Roy Wong - Major Project Modification Application MP 08_0258 MOD 5 - Council Submission

Major Project Modification Application MP 08_0258 MOD 5 61 Mobbs Lane - Epping – Former Channel 7 Site (Epping Park)

I refer to the public exhibition of the above Major Project seeking approval for the modification of the Early Works Package in relation to the child care centre.

SITE & ROOF PLAN 1:500

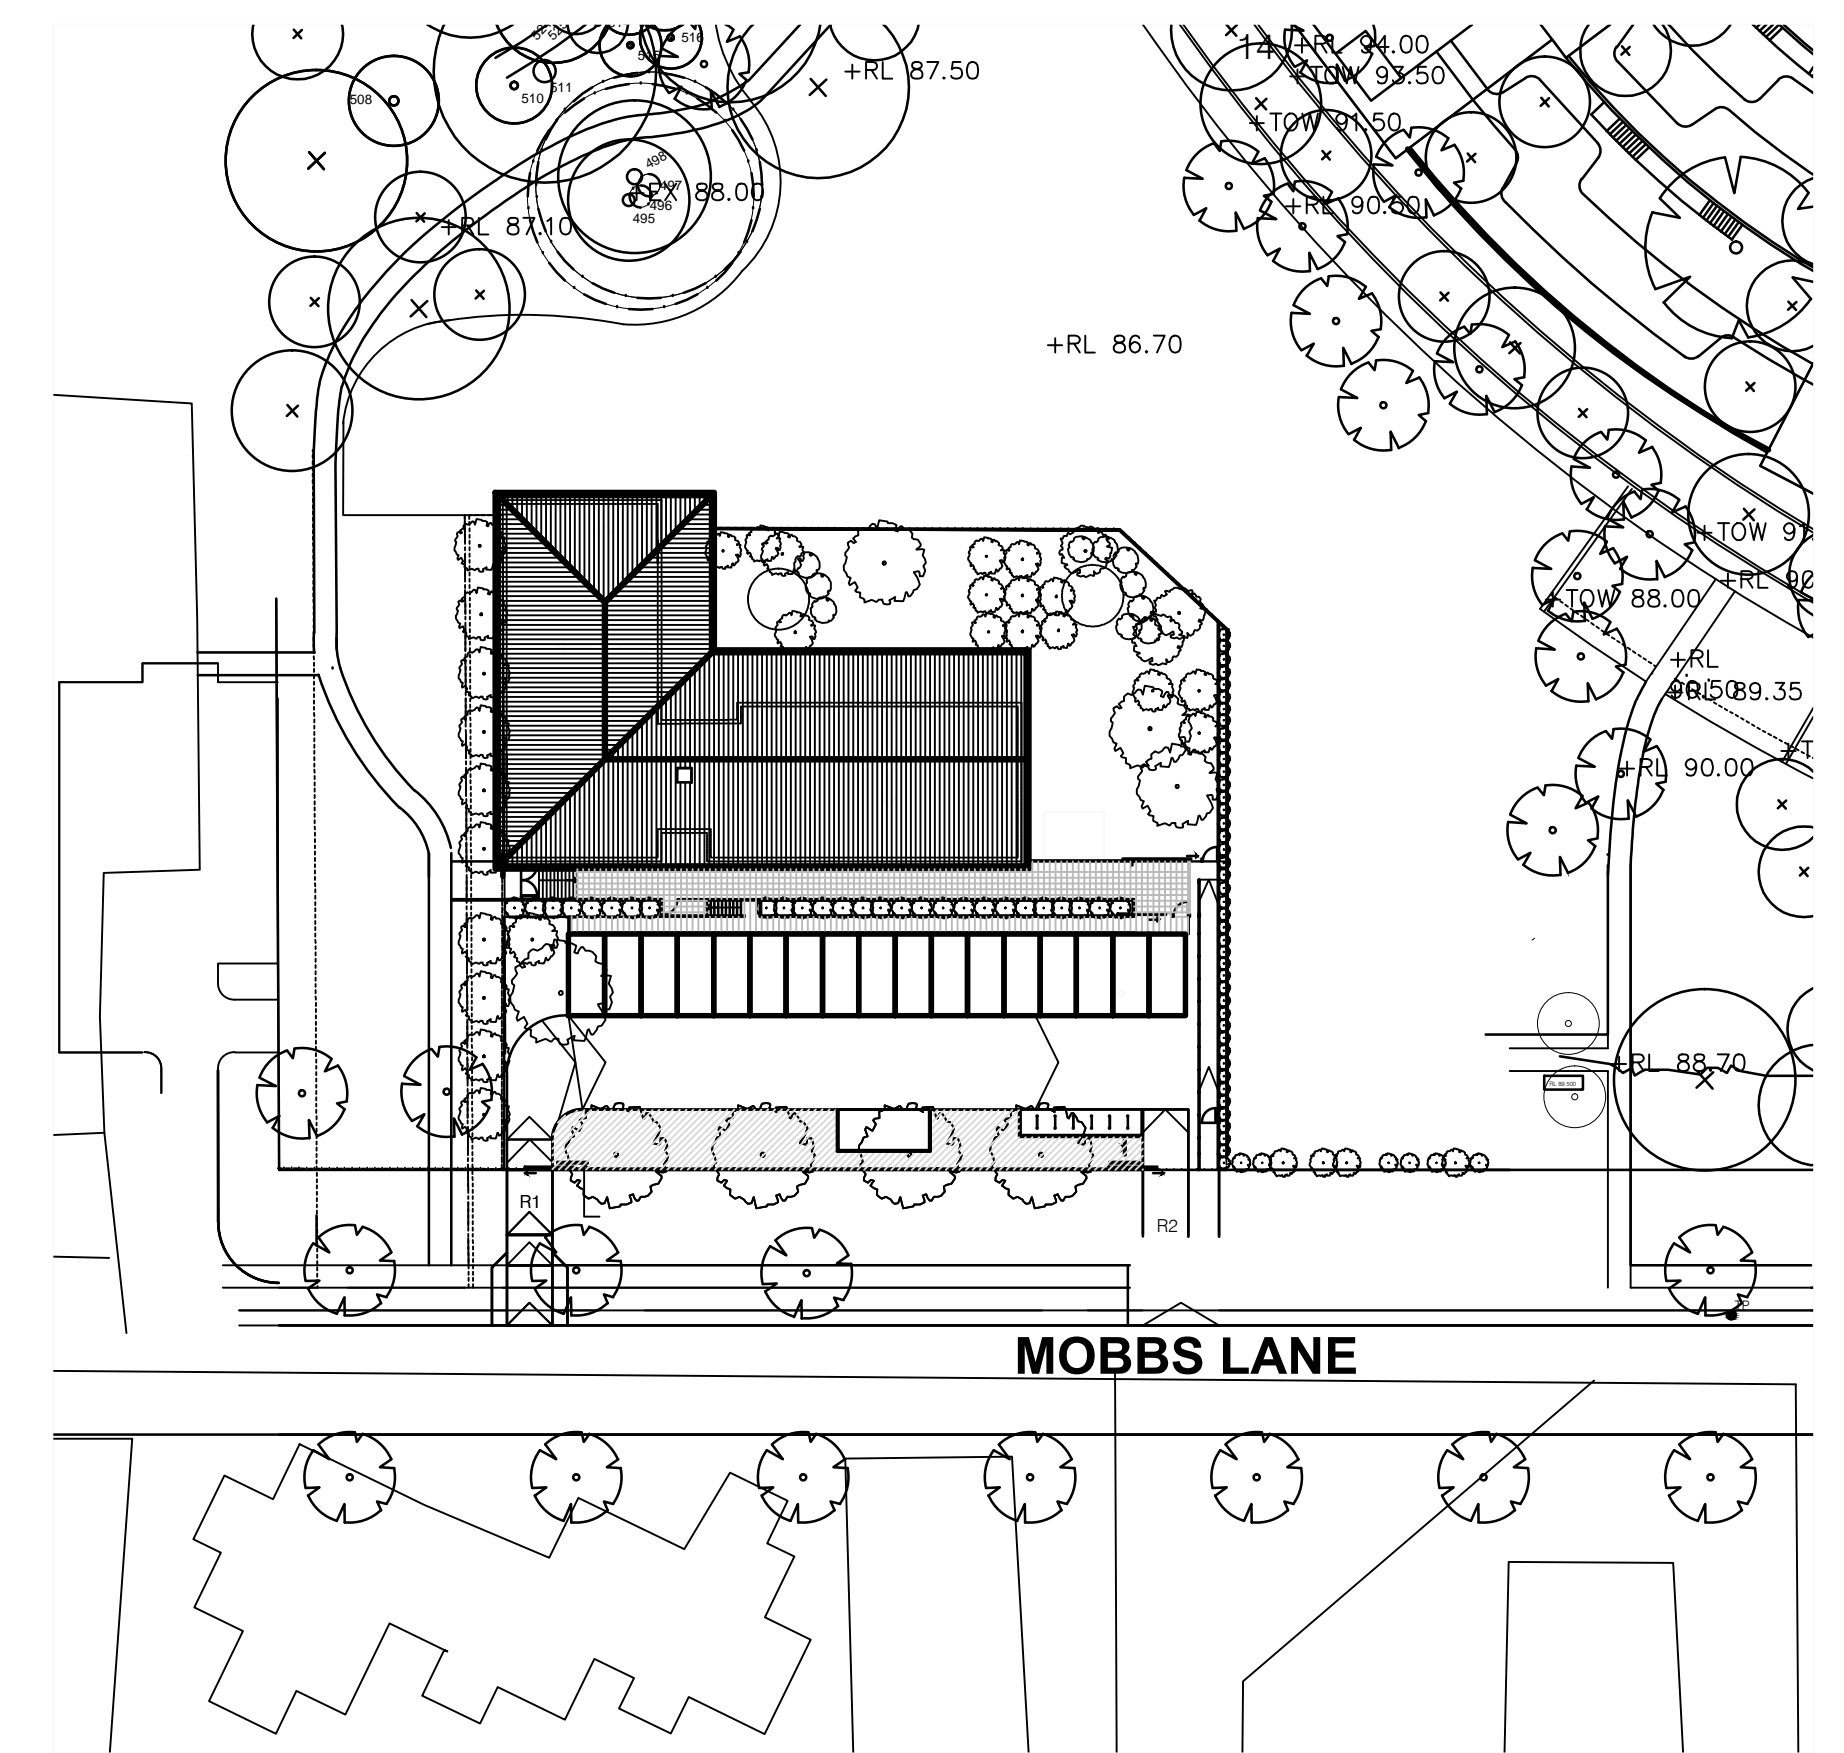
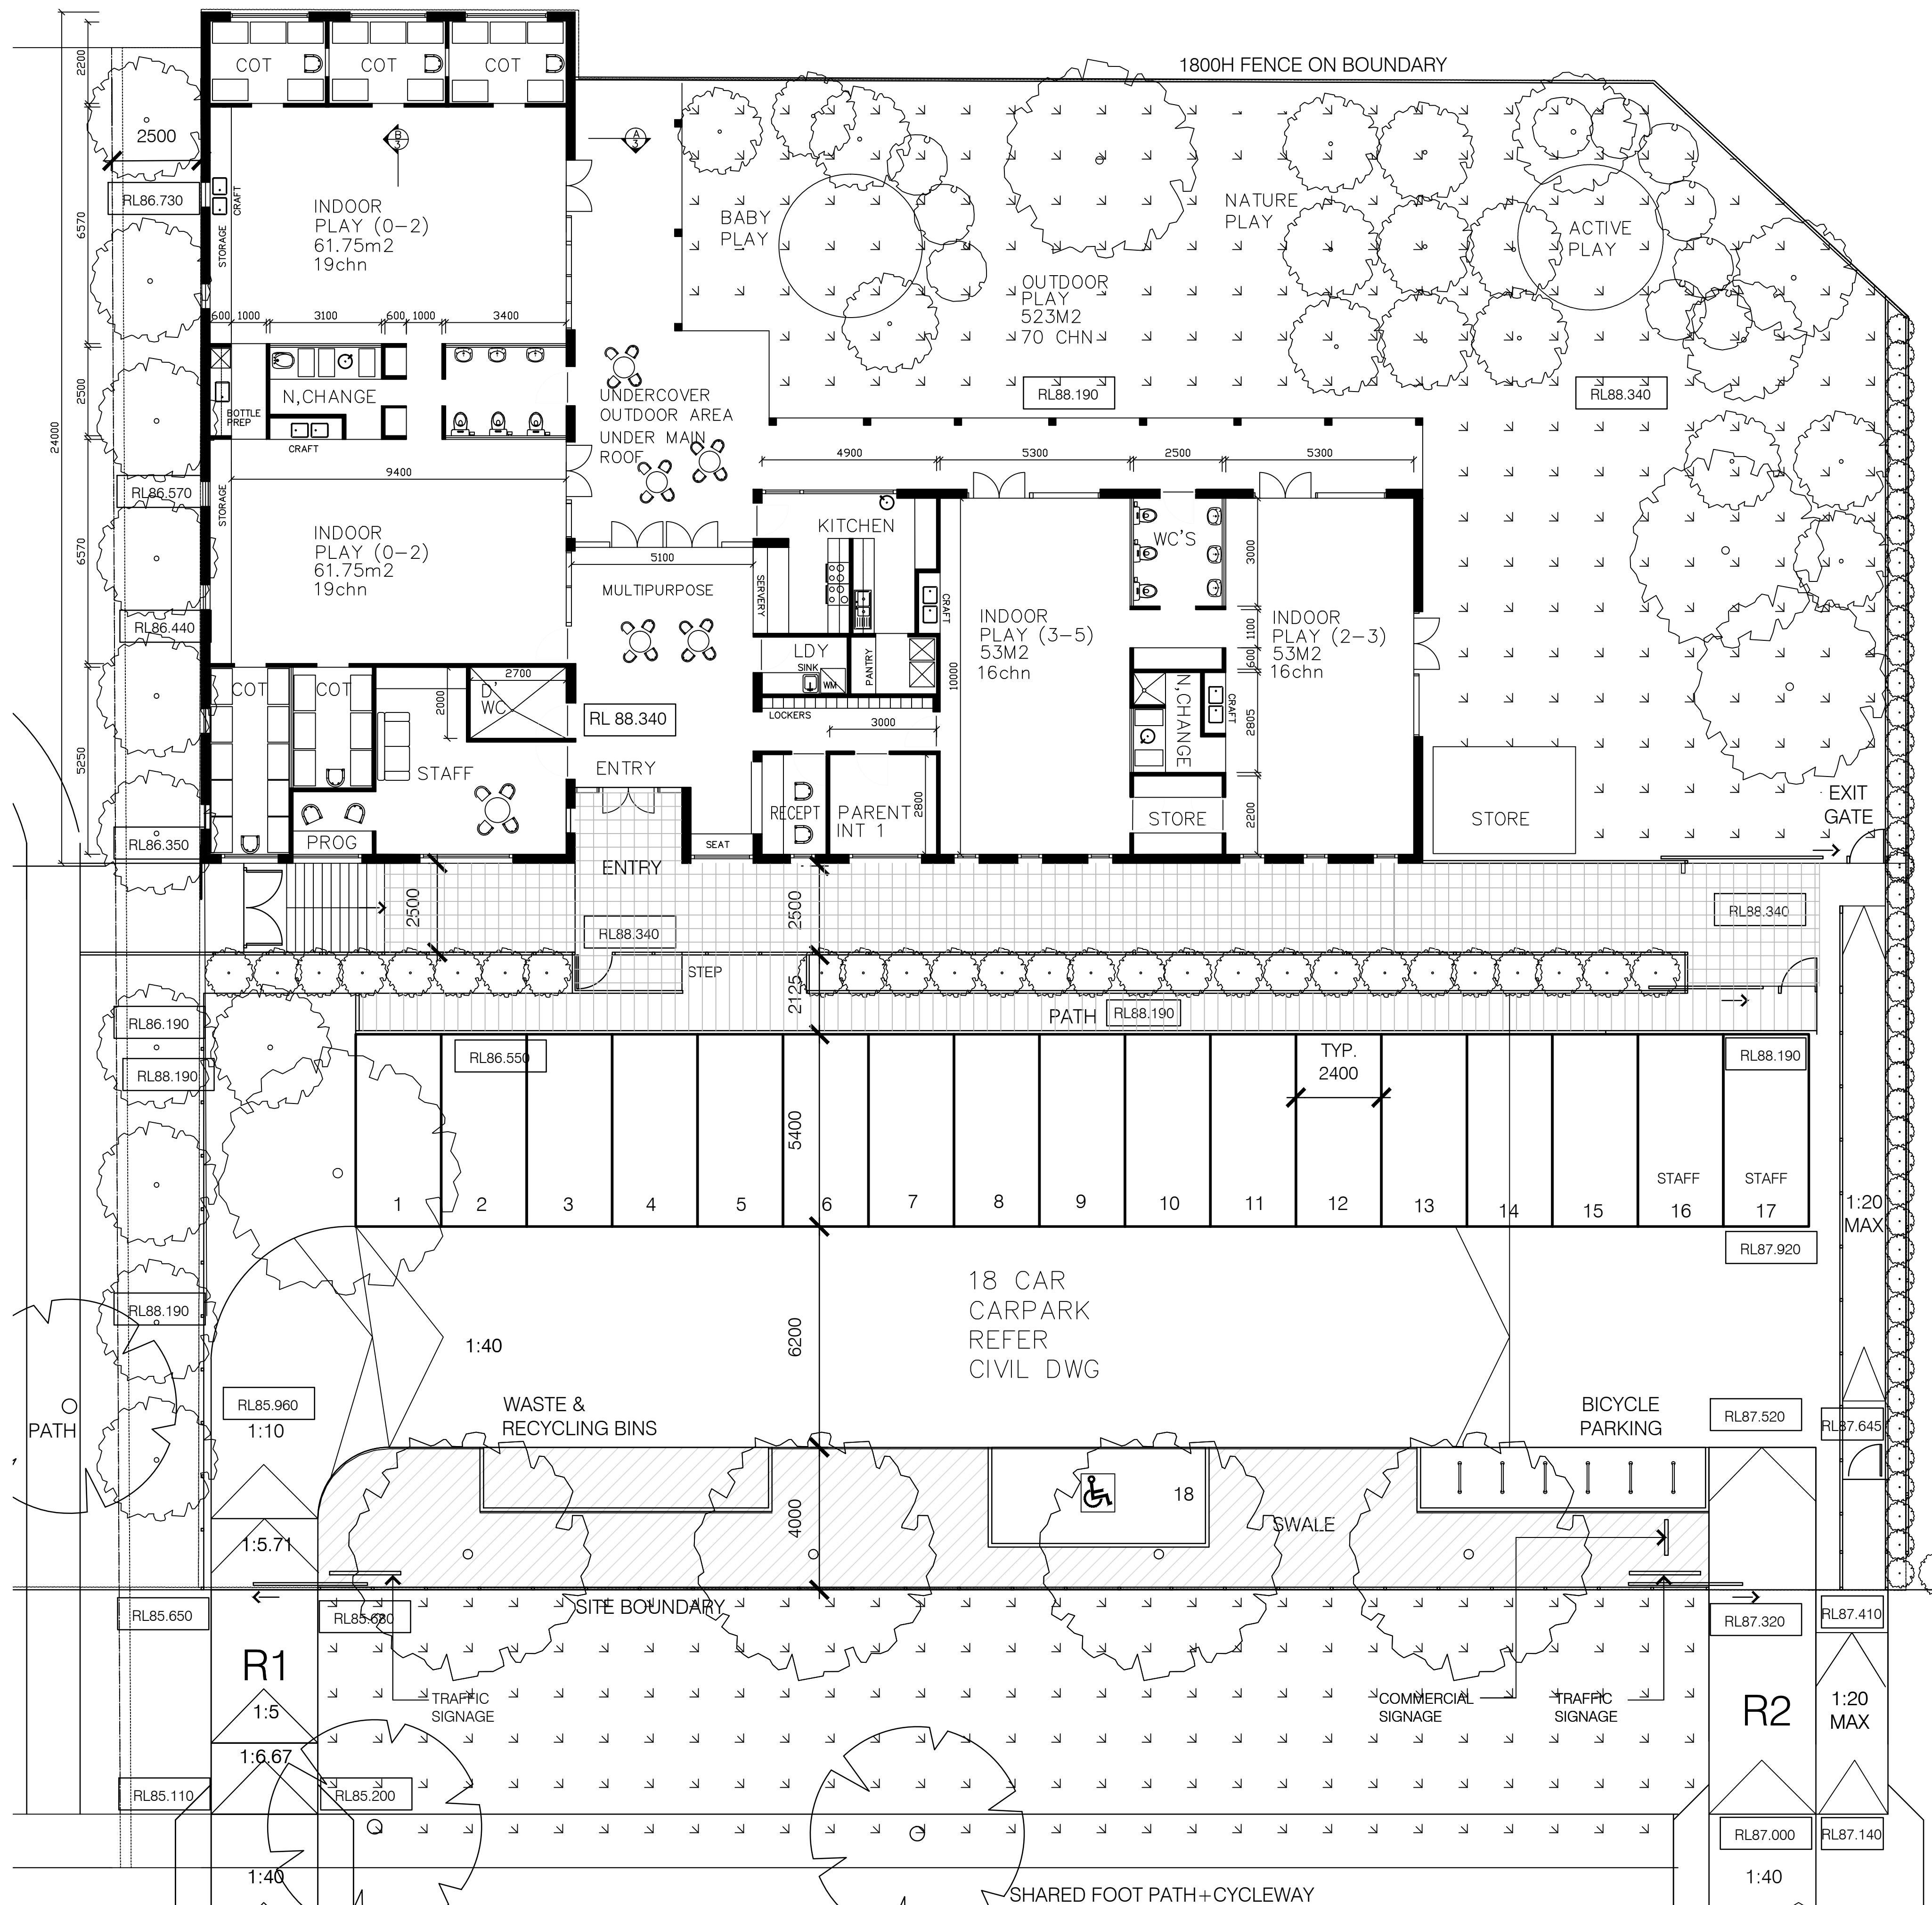
- The number of car parking spaces complies with Council's minimum requirements (18 spaces).
- Concern is raised that the location of the disabled car space will result in a loss of landscaped area within the front setback. Notwithstanding this, the location is acceptable provided:
 - The disabled car space is to be designed in accordance with AS1428.1 and AS2890.6.
 - The landscaped area adjoining the car space is to be appropriately planted to reduce the visual impacts of the car parking area.

- Concern is raised that the location of the waste area will result in a further loss of landscaped area in the front setback. The location of the waste area will adversely

impact upon amenity of the streetscape and the public domain.

Council requests this waste area be relocated away from the front setback and be appropriately screened from public view.
